12 March 2021

## 1. Waterloo Metro Quarter Over Station Development – Response to Authority Comments

ptc. have been engaged by WL Developer Trust (WLD) to prepare a response to traffic related comments raised by the Authorities in relation to the proposed Waterloo Metro Quarter Over Station Development.

Figure 1 - Access to Retail Tenancies from Northern Loading Dock

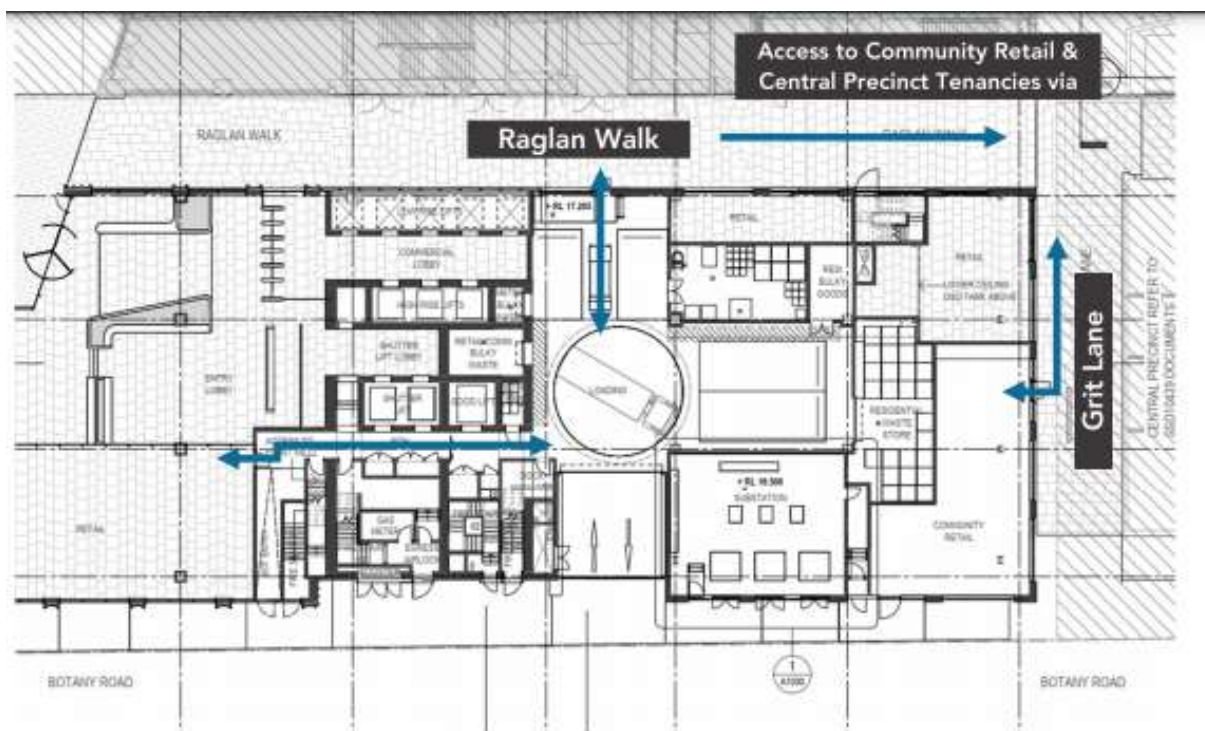
*Provide further information on how the proposed retail premises can be serviced from basement loading docks.*

### 2.3.4 ptc. Response to Item 7(e)

Access from the Central Precinct retail tenancies to the Northern loading dock is provided in the following diagrams.
